The quality of the land in and around Sturton le Steeple by the applicant's own "testing" indicates that 88.3% of the development would be on agricultural land of grade 3a OR ABOVE (found on page 21, of Chapter 15: Land Use and Agriculture Environmental Statement – Volume 1).

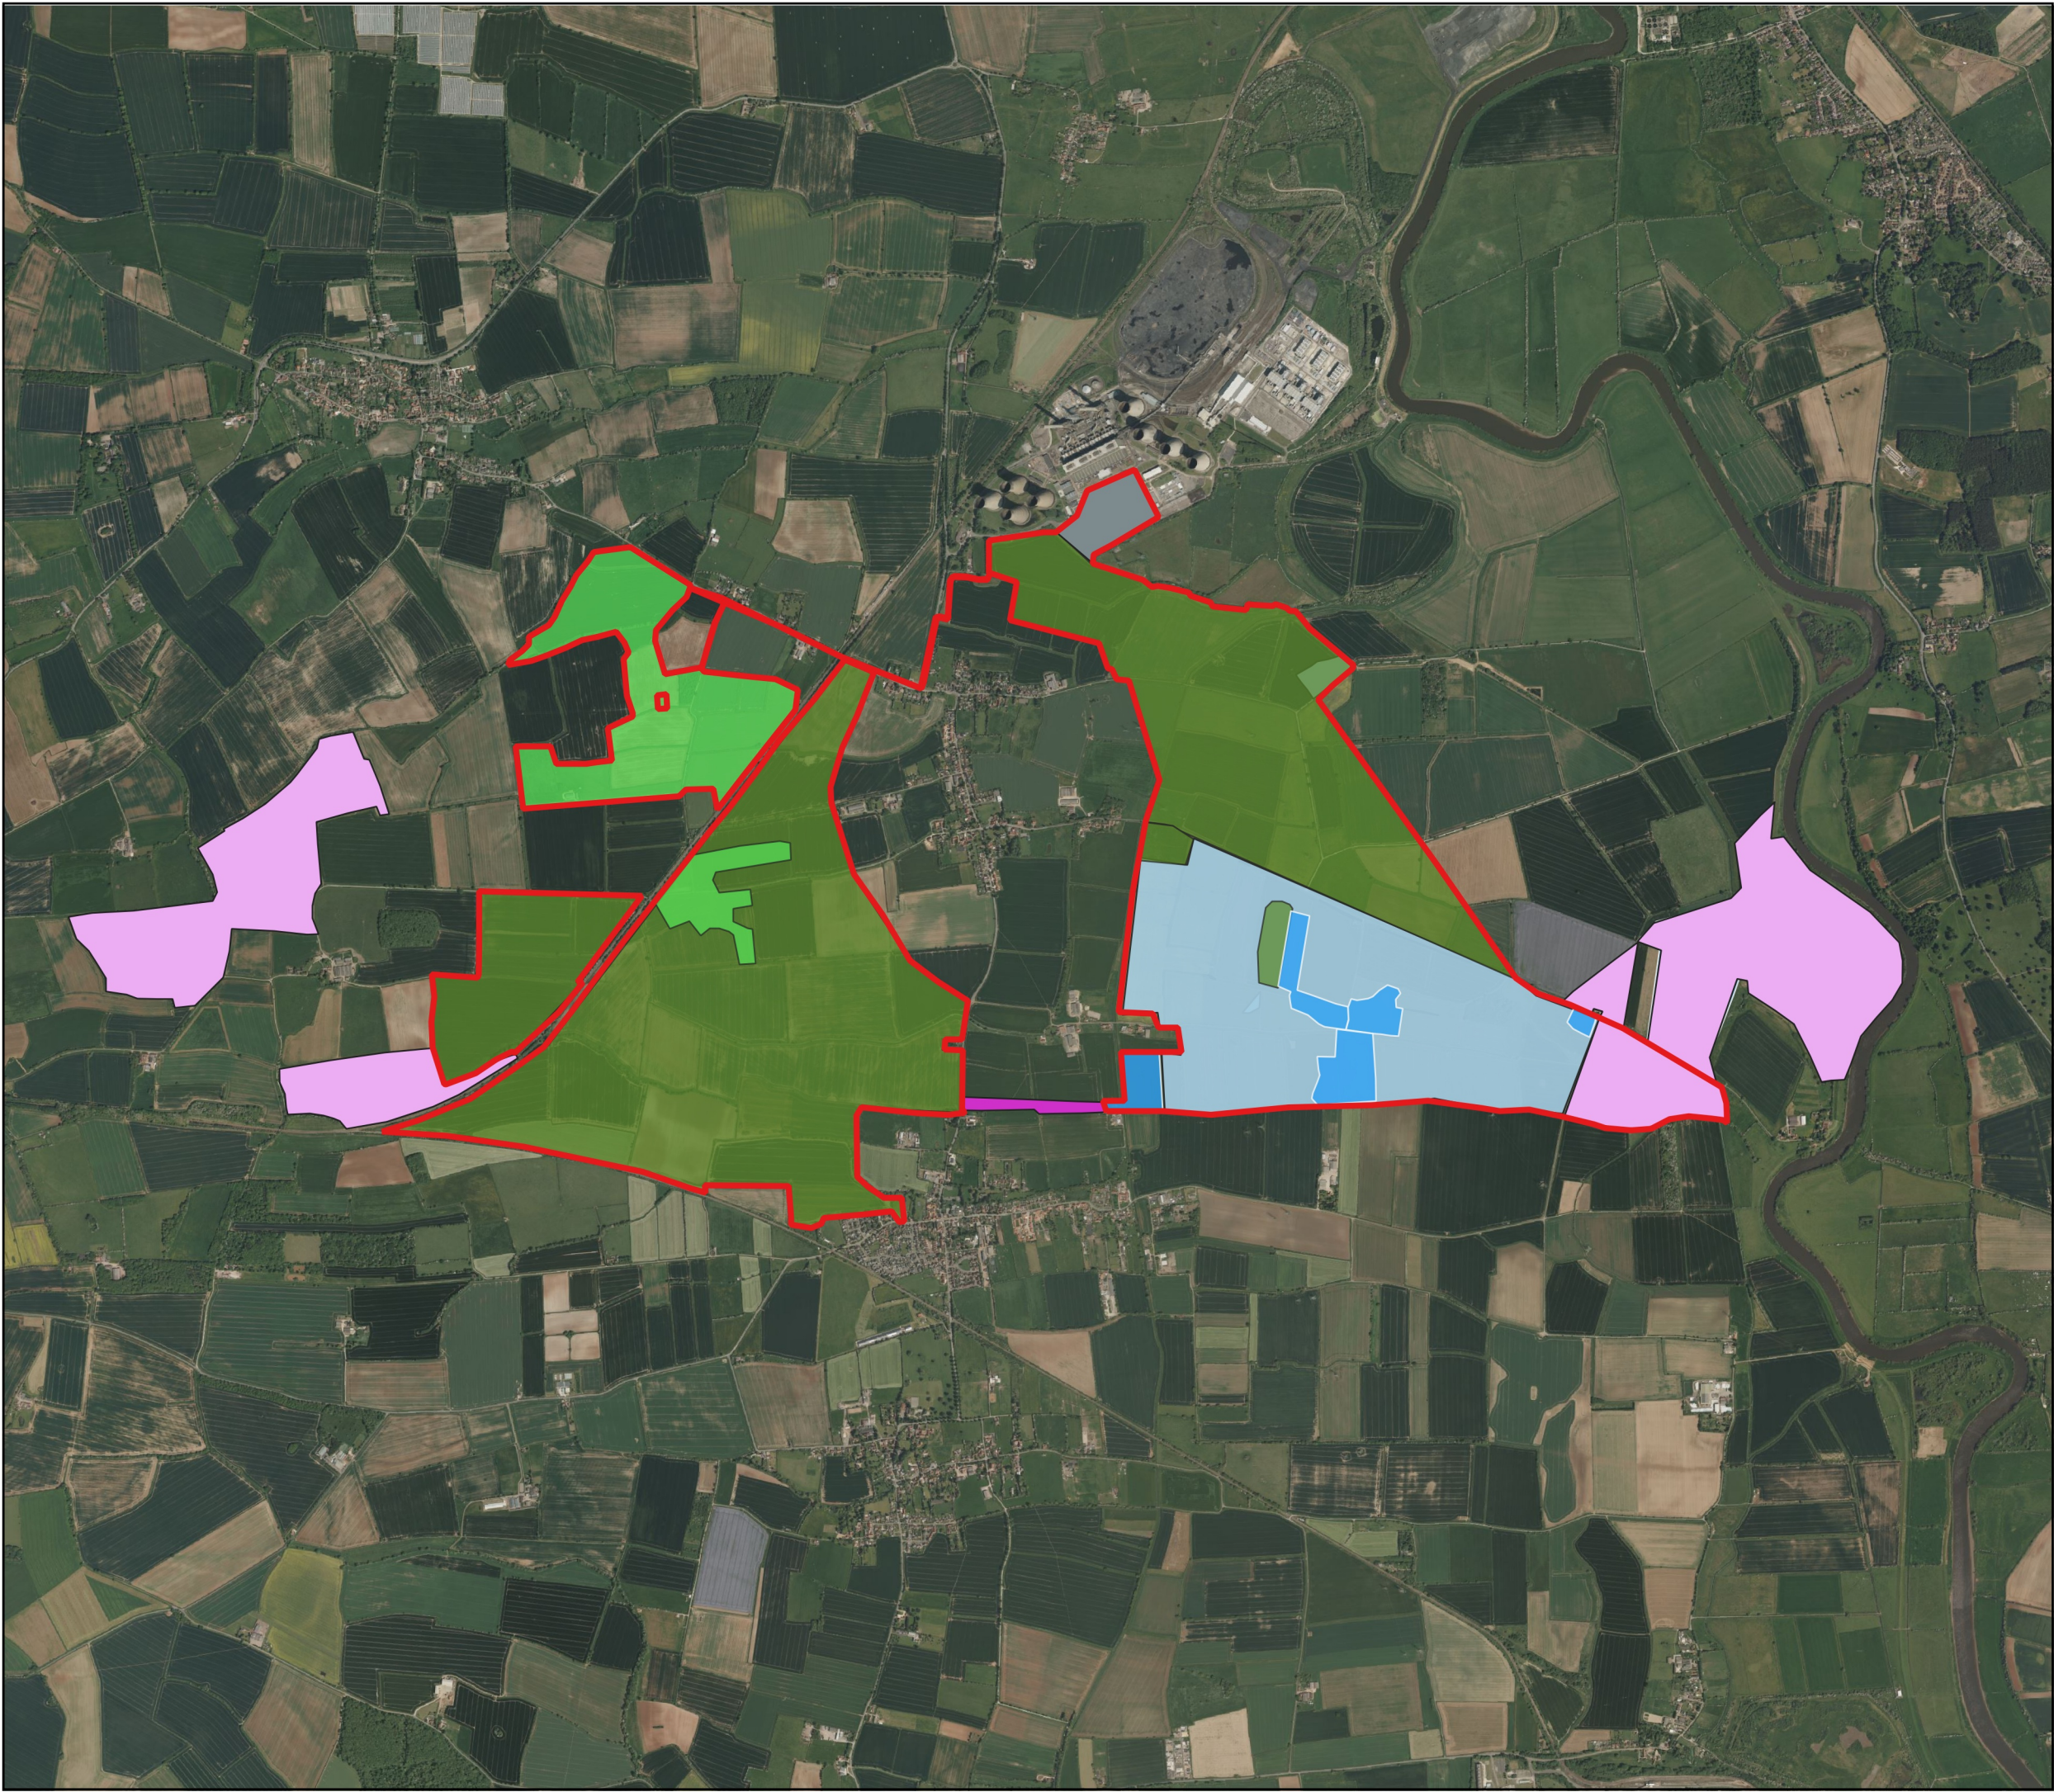
The applicants "testing" data is dubious at best. How many soil samples were taken across the 1700 acres to be developed on? Or did they simply rely on historic soil data comprised in the 1970's and 80s?

As soil quality can vary across just a few acres of the same field, then a comprehensive survey showing the true soil quality should have included approximately 850 samples (based on one sample per two acres). Why was this not undertaken?
